**Re: Hillside Auto
134 Tennessee NE
Request for Certificate of Occupancy- Transportation Development**
Engineer's/Architect's Stamp dated 1-22-16 (K19-D148)
Certification dated 1-21-16

Based upon the information provided in your submittal received 1-25-16,
Transportation Development cannot issue Certificate of Occupancy for the above
referenced project.

TRAFFIC CIRCULATION LAYOUT

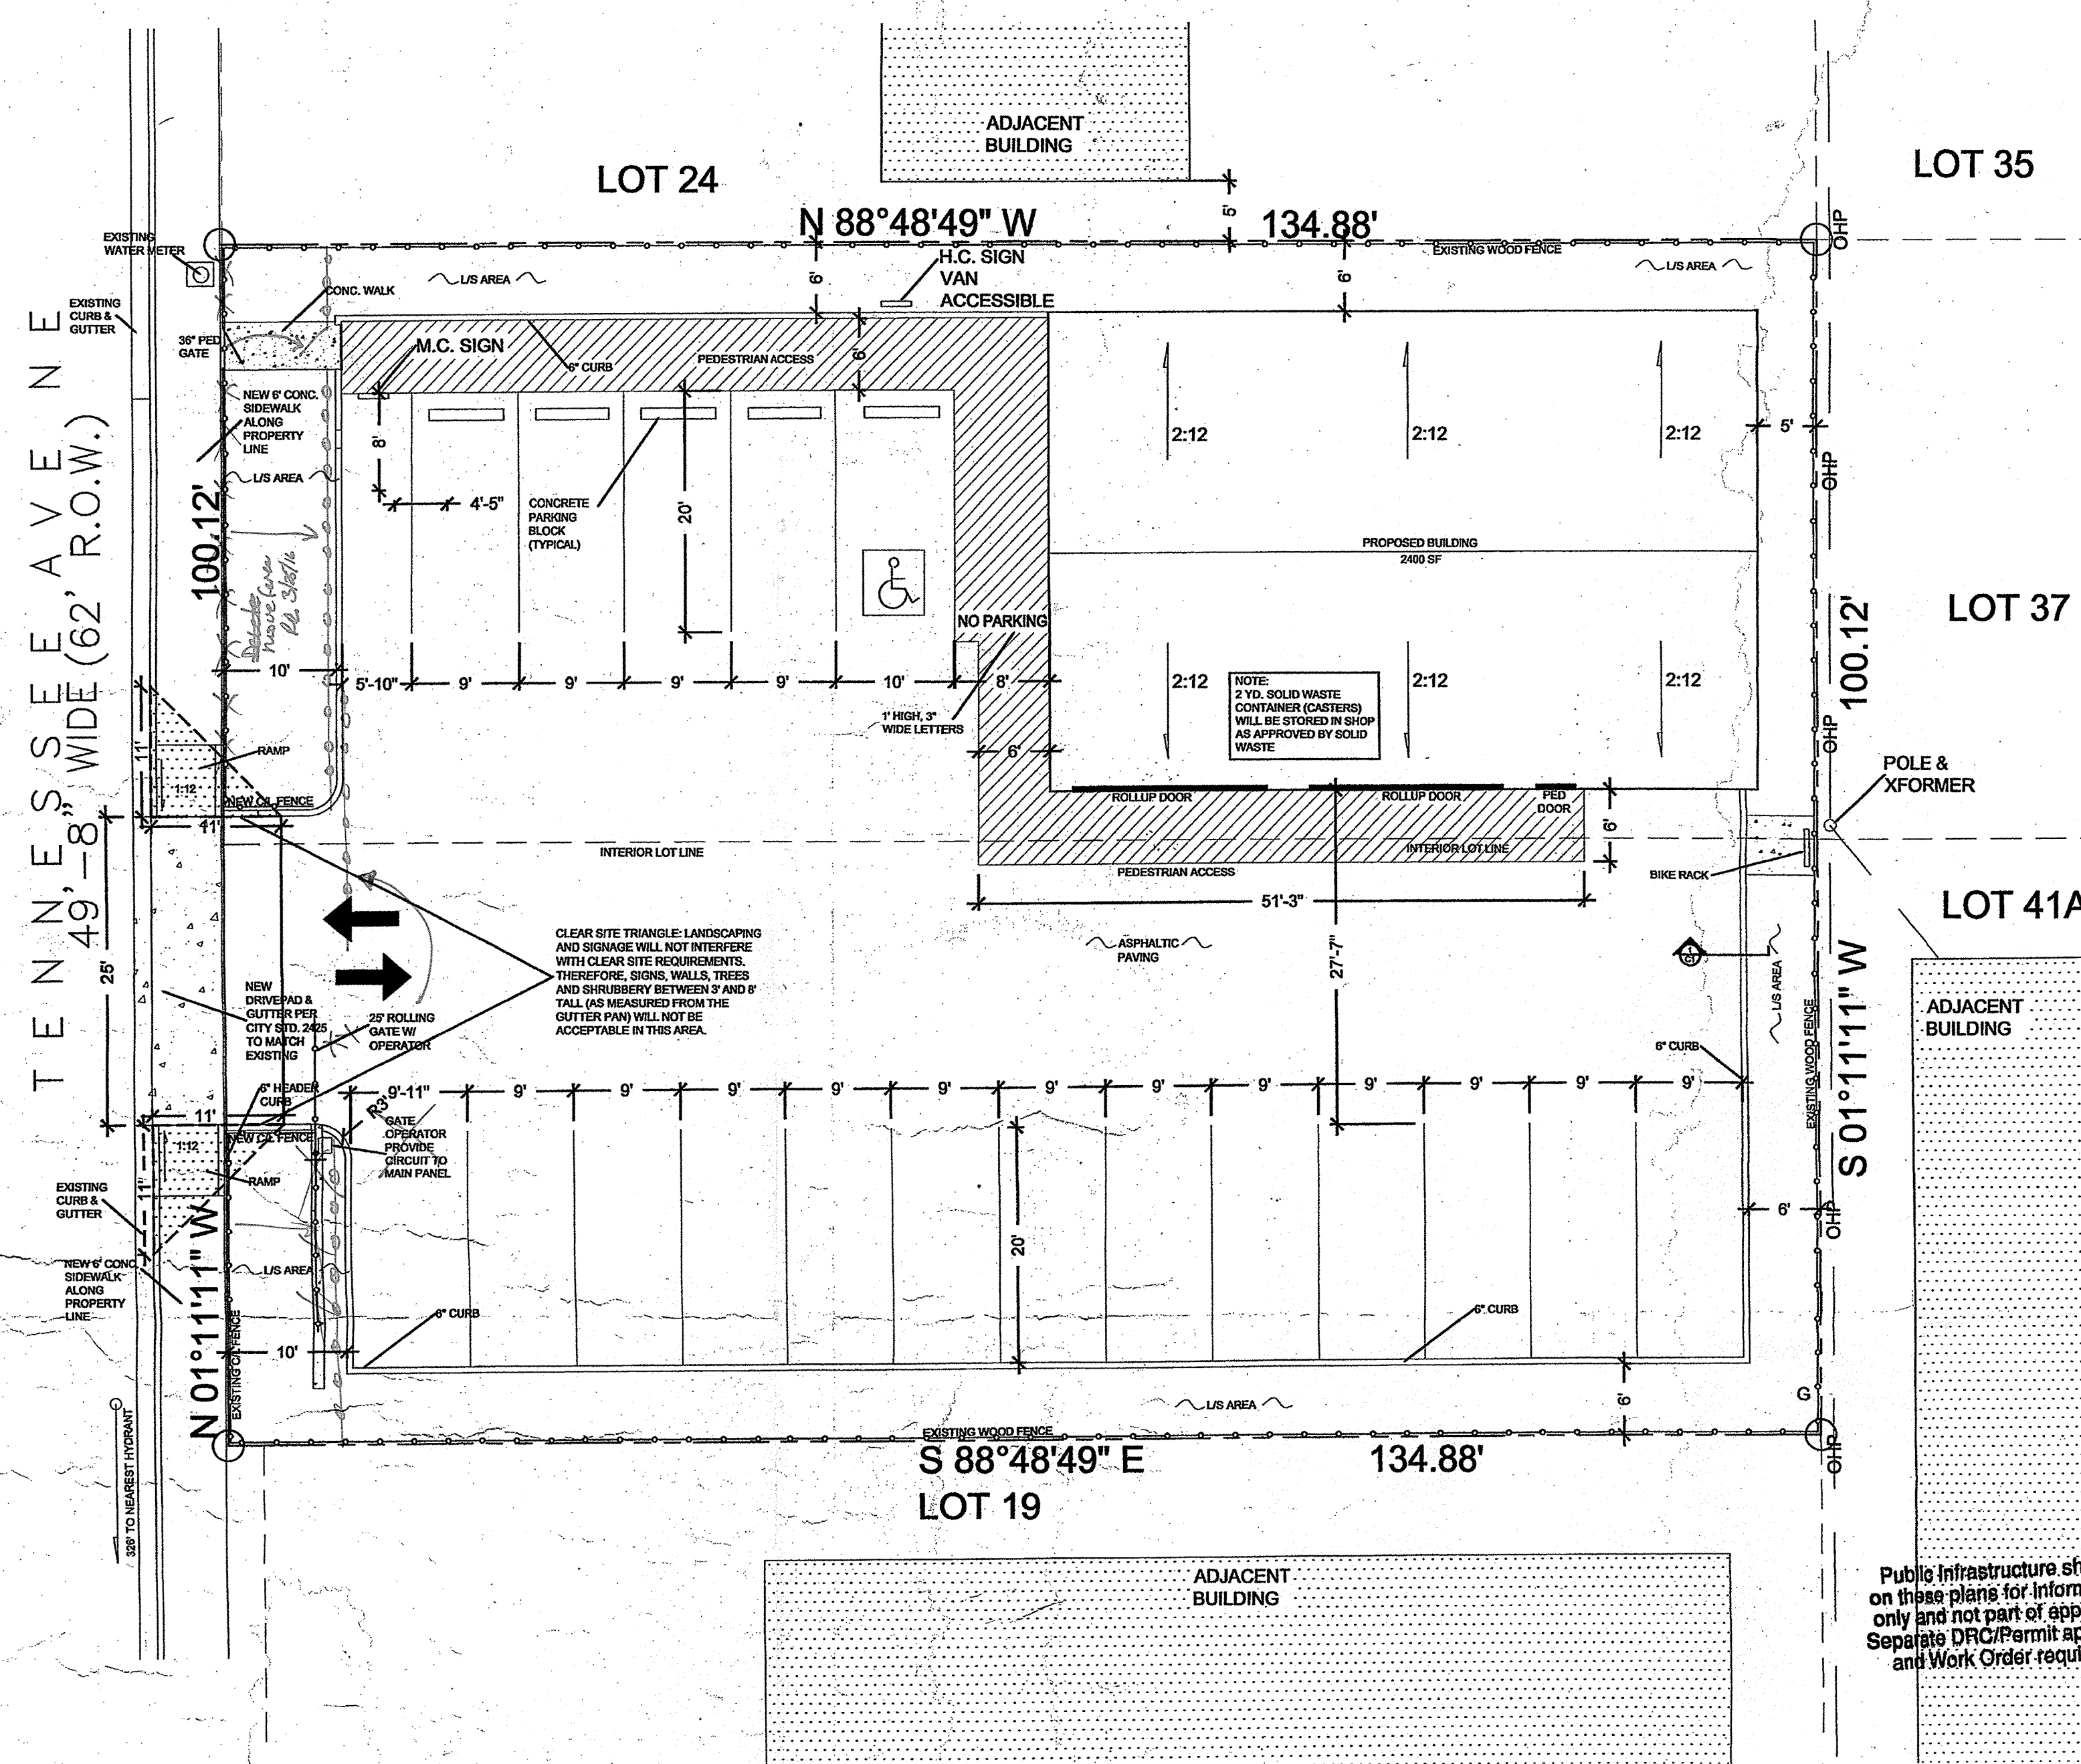
- Completion of parking lot striping and installation of ADA signs.
- Project site must be available for on-site inspection.
- Please submit the TCL Approved drawing when project is completed.
